**From:** Bill Larkin  
**Sent:** Monday, 24 October 2022 10:23 AM  
**To:** Nima Salek  
**Cc:** Rose-Anne Hawkeswood; Dimitri Young; Don Owner  
**Subject:** RE: meeting request: referral follow up, DOC22/653005, Crescent Head Ilmenite Stockpile Rehabilitation, (SSD-30956841), PAE-49306961

## Crescent Head Ilmenite Stockpile Impact Areas

FIGURE FOUR - STOCKPILE REMOVAL ZONE

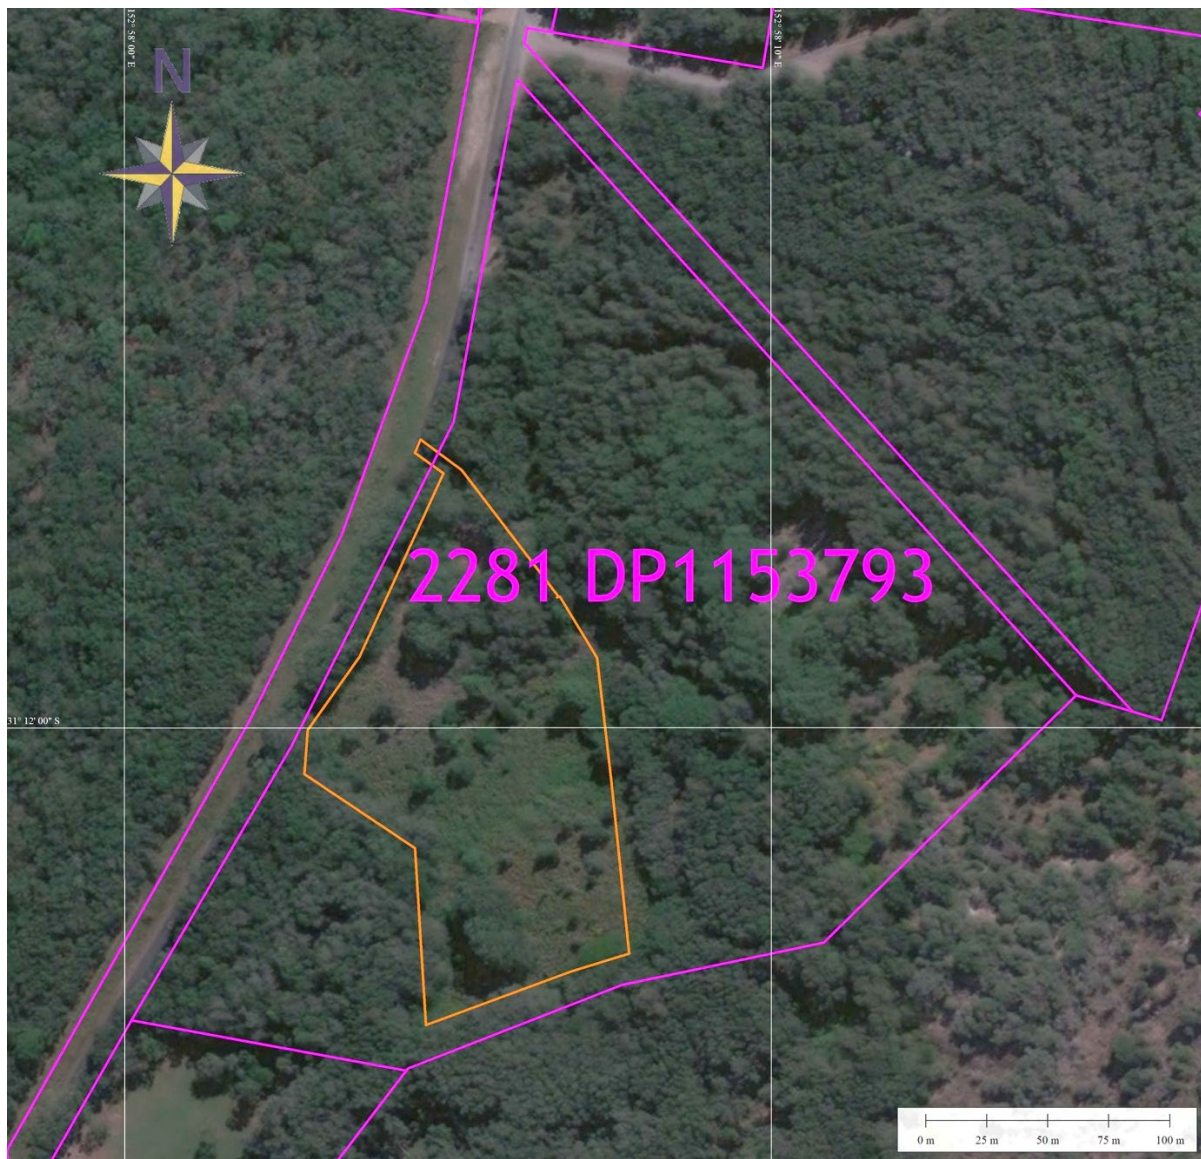
The BCD accepts the response from GER to recommendation 2(a), however the condition of consent should specify the correct figures from the BDAR/EIS for the project application area to ensure additional clearing does not occur in accordance with the Figure 4 of the project execution plan.

- a) GER notes the departments concerns with the mapping shown in **Appendix Two – Project Execution Plan**. The mapping shown on **page 15, Figure 4 of the Project Execution Plan** is titled “Approximate ilmenite stockpile boundary...” for that very reason it is for illustrative purposes only and the BDAR impact area, similar to the **project application area, EIS section 2.1.1, page 3** and all other remaining figures will be the boundary used for all works and disturbance.

FIGURE SIX - PLANT COMMUNITY TYPES

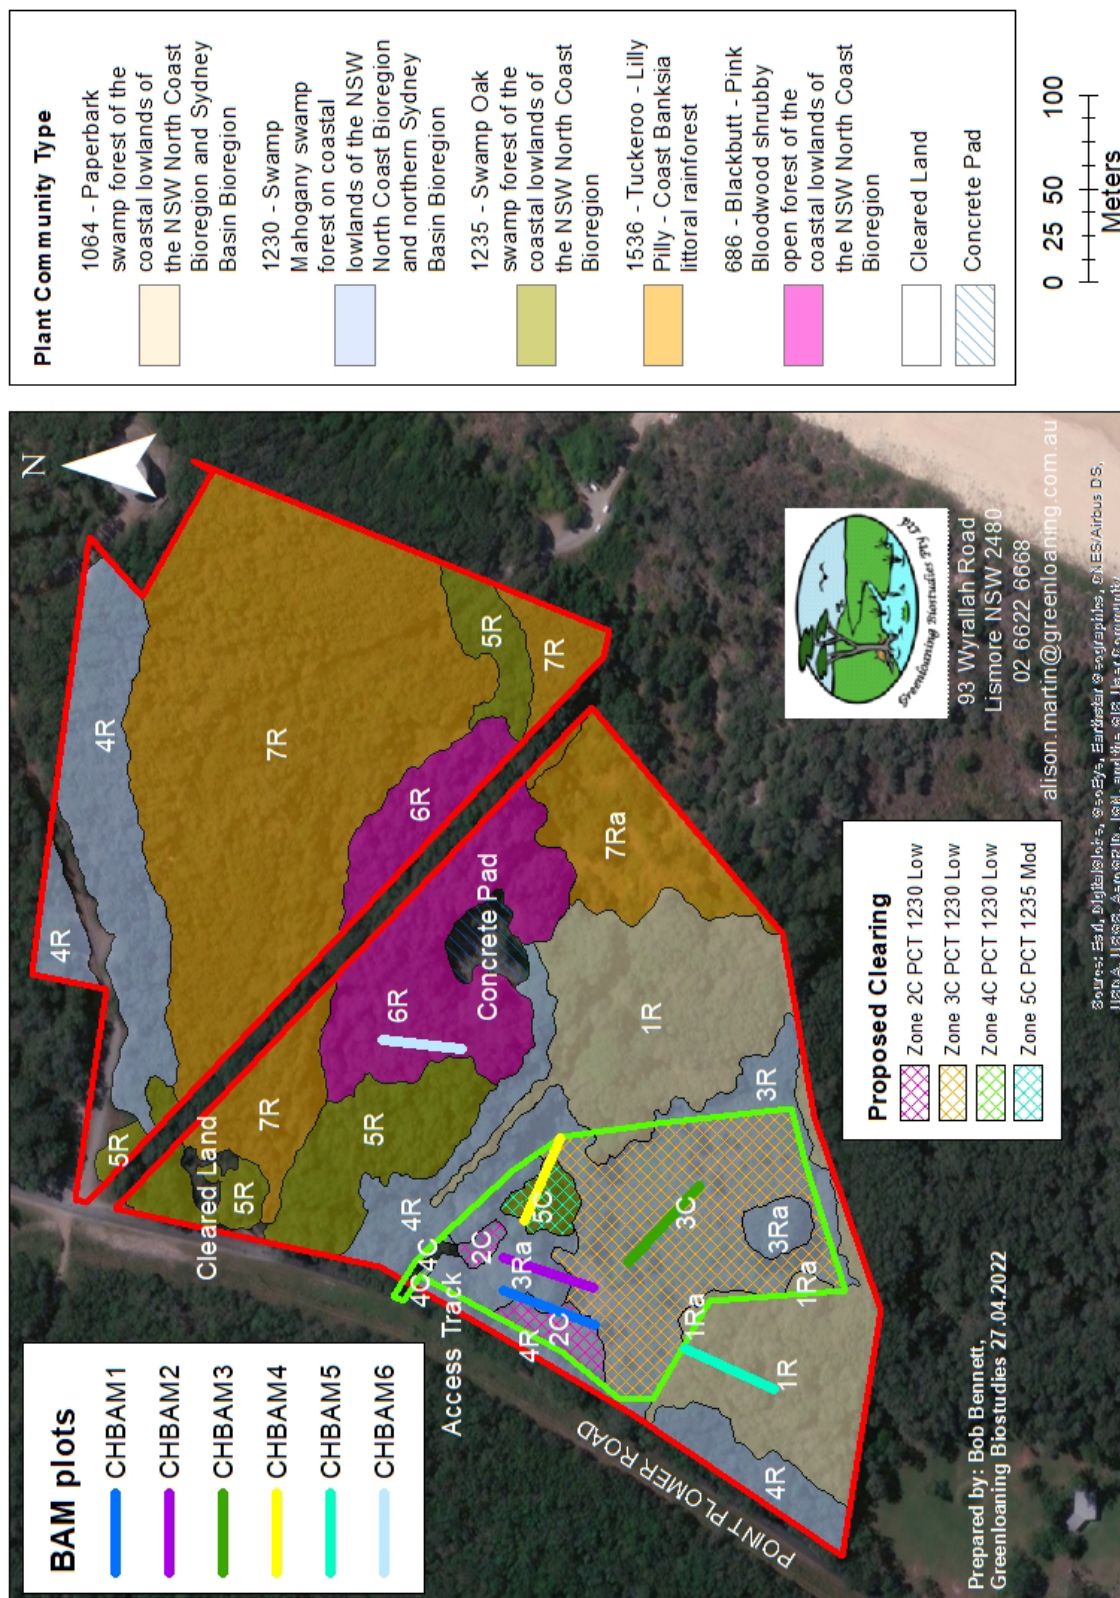
Regarding the RTS Response to recommendation 2(b), we note from Figure 15 and Figure 18 of the BDAR (see below) and verified from site inspection carried out by BCD officer, the stockpile contains patches of native vegetation. This has been mapped in the BDAR as zone 3Ra which is PCT 1230 in moderate condition. The GER response in the RTS indicates that the entire site is covered in weeds and that there is no ecological value in retaining the vegetation on the stockpile and it will be removed and disposed of off-site or burned. This contradicts what vegetation is mapped in the BDAR and verified by a BCD officer on-site.

Hence the BDAR will need to be revised to include all impacts to native vegetation that will be removed from the stockpile during the activity and the BAM-calculator updated accordingly.
